From: Anita Gardner
Sent: 04 October 2011 14:19
To: Planning.Responses
Subject: FW: LU/245/10 Security fencing to boundary, security lighting to access road and construction of additional pontoon moorings Land on West bank of River Arun , Littlehampton

Subject LU/245/10 Security fencing to boundary, security lighting to access road and construction of additional pontoon moorings Land on West bank of River Arun , Littlehampton

Don,
 Following our previous correspondence regarding the above application I have received some additional information from the agent this includes substitute landscaping proposals, drawing no. 2106/PL/01/1 and lighting details. The agent has advised that the lighting would operate by motion sensors and that the security fencing is new.

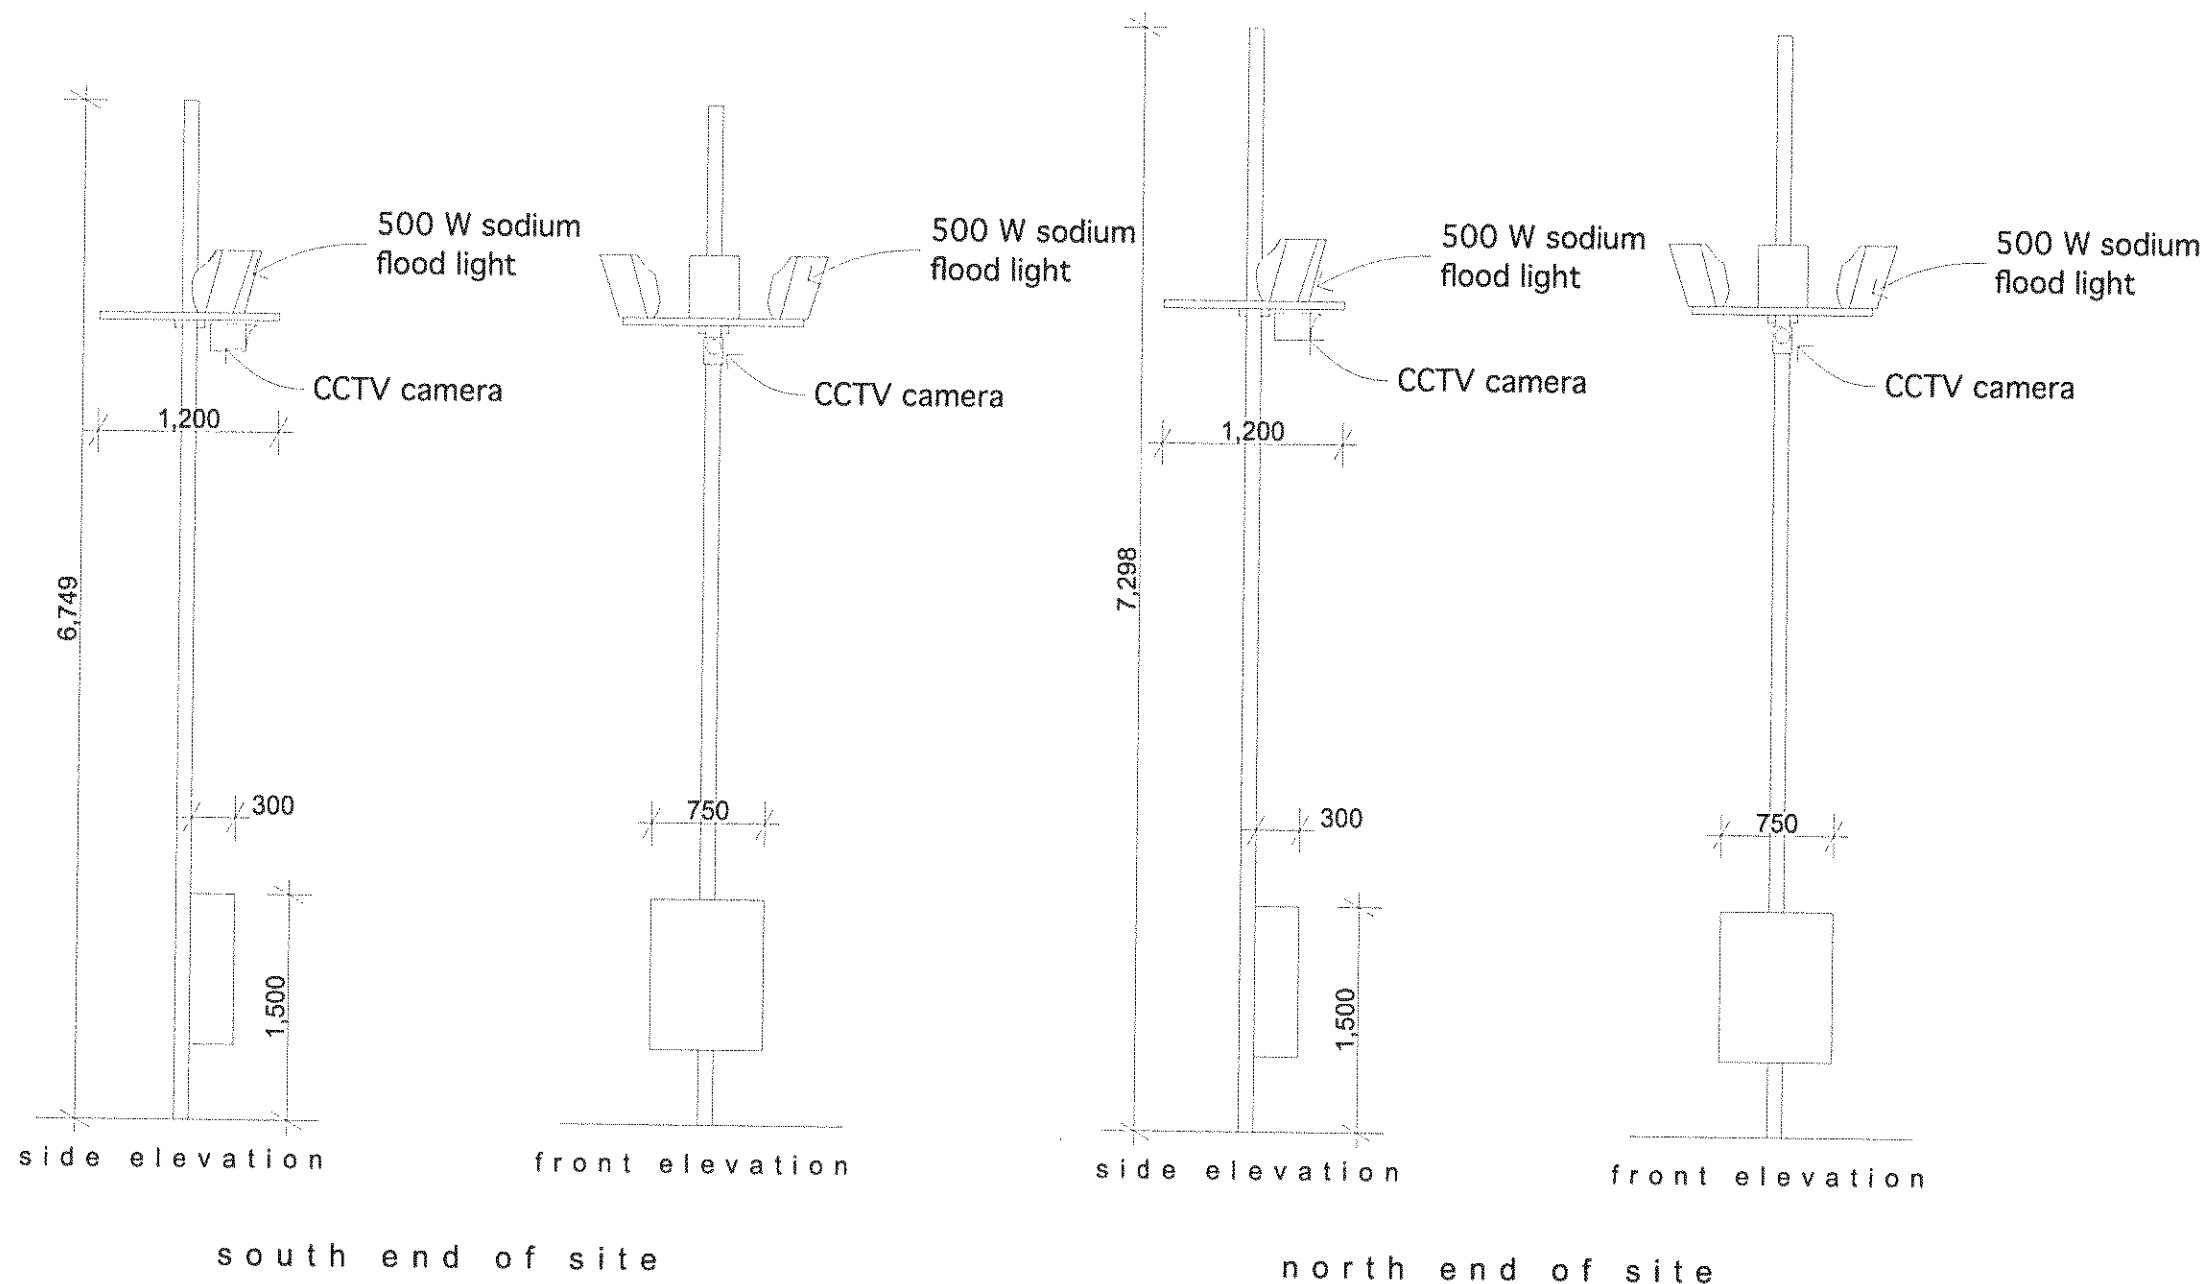
Anita,
 I am pleased to see the native planting and that the lights will have motion sensors. The plans seem to indicate that the sand catchfly (the rare plant there) will be protected through "robust ranch style open fencing". So I think those are the major issues dealt with so far as I understand the application.
